Application No: P/73/21/HH
Site Address: 6 The Green Pagham PO21 4RZ
Description of works: Loft conversion to form new first floor with front and rear dormer projections (resubmission following P/21/21/HH).

Thank you for your internet representation made on 4th June 2021 which has been recorded as an objection with the comments as follows:

1st floor plan
1 : 50

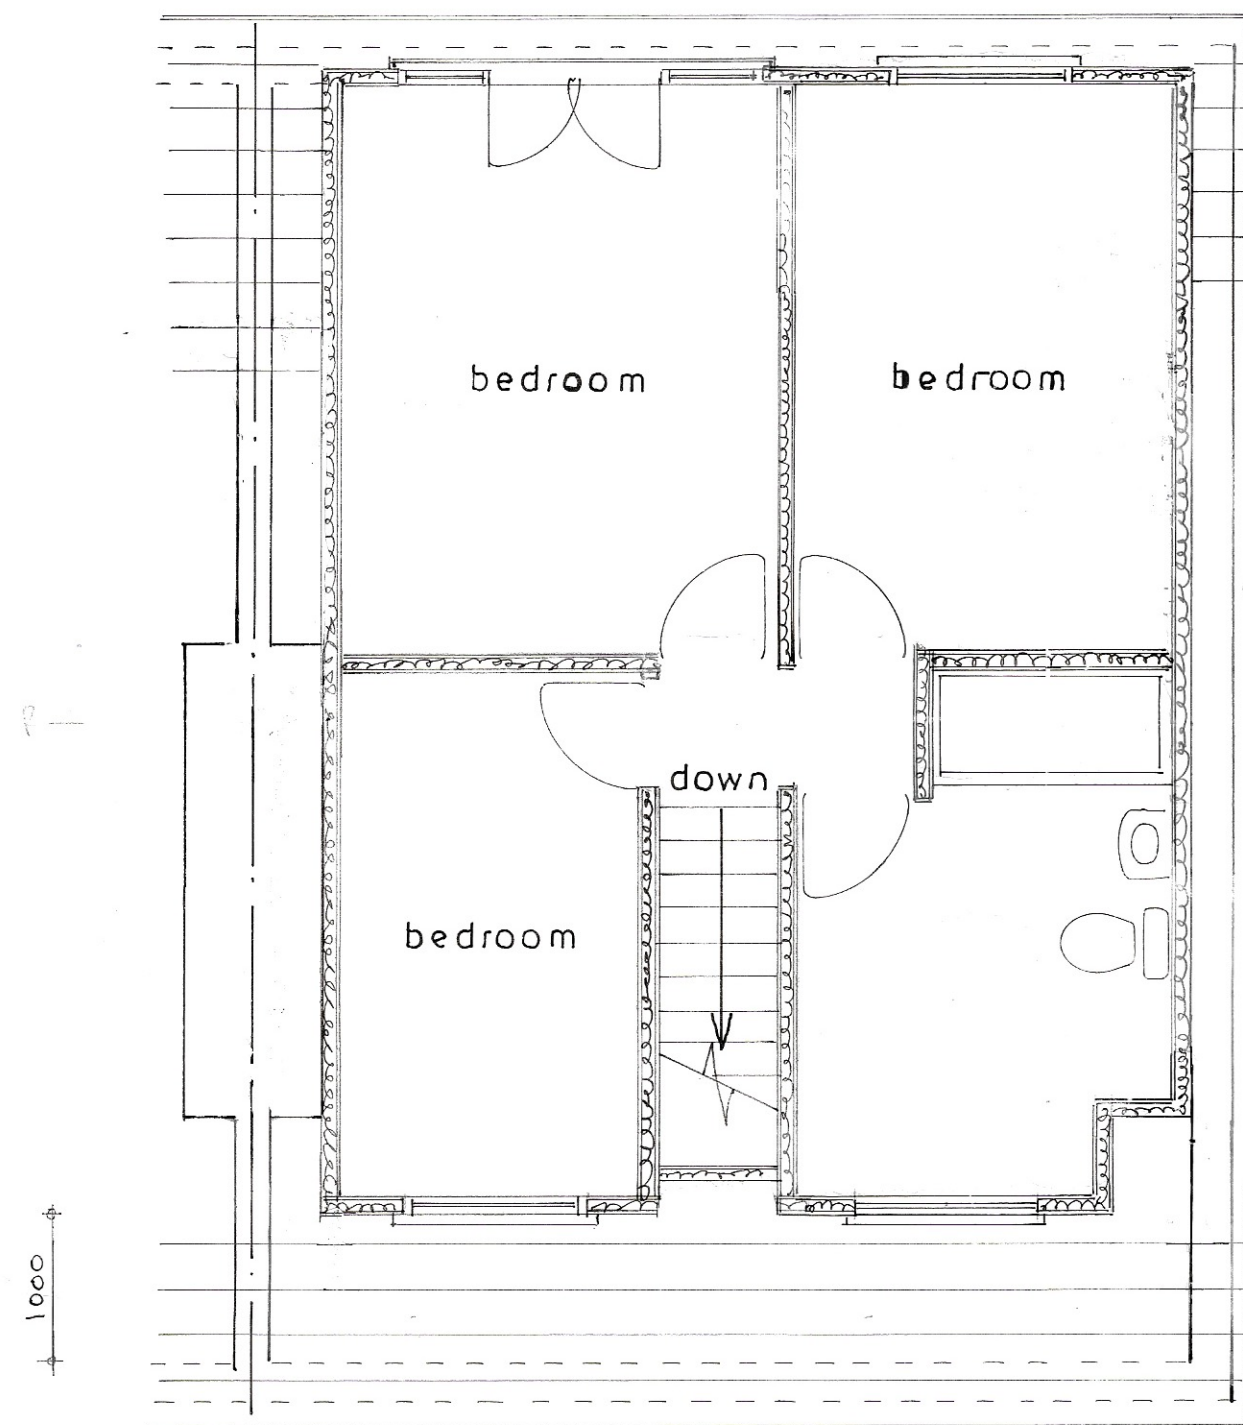
I see the layout is the same, 3 bedrooms, 1 bathroom, how can this be possible in the reduced roof space in a 2 bedroom semi detached bungalow.

south-west

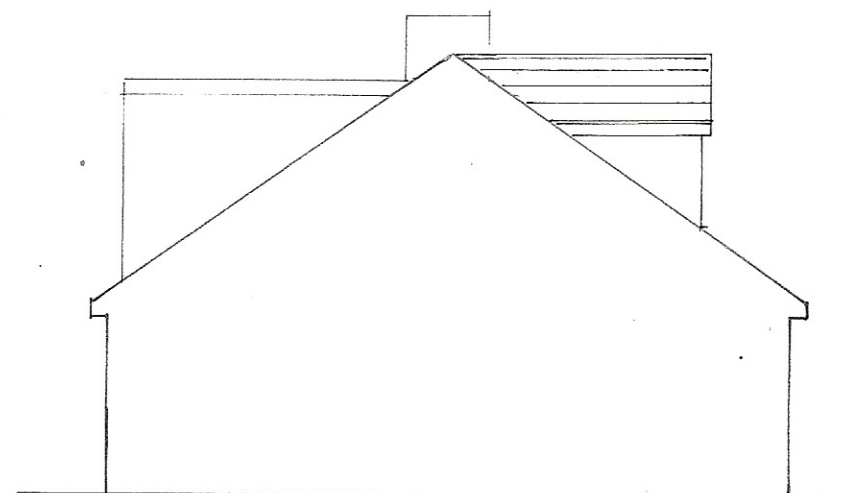
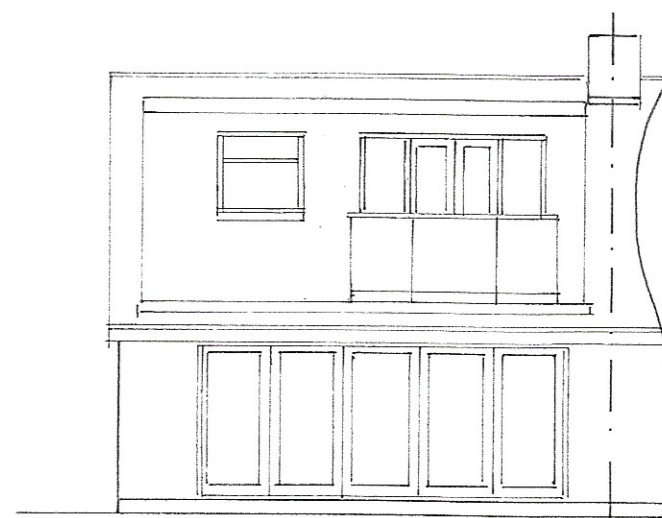
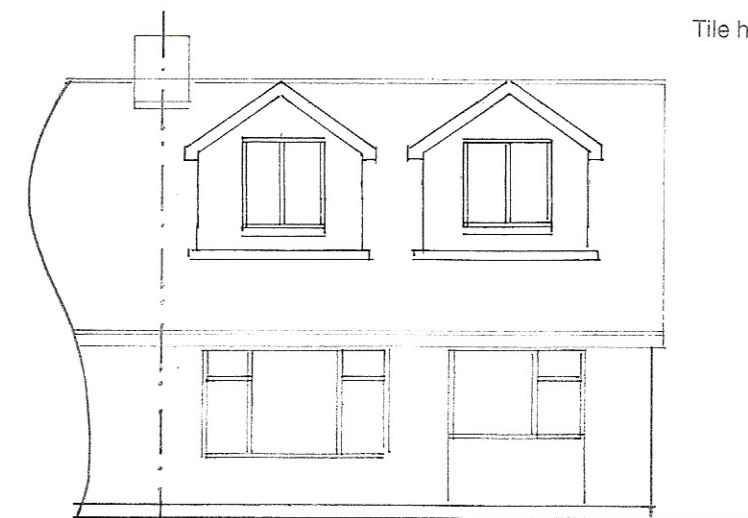
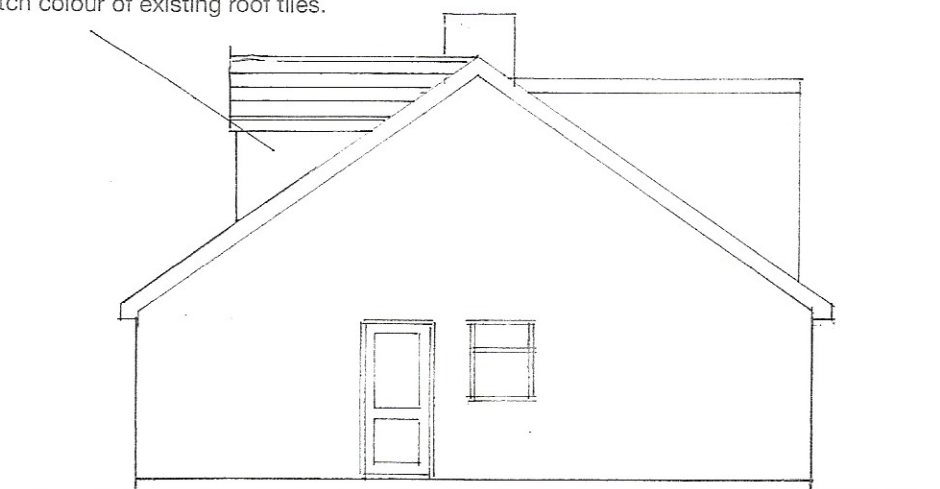
It still not in keeping with the properties in this bungalowed road that has no front dormers.

This new front dormer and the rear dormer will seriously impact the value of my property should I wish to sell in the future.
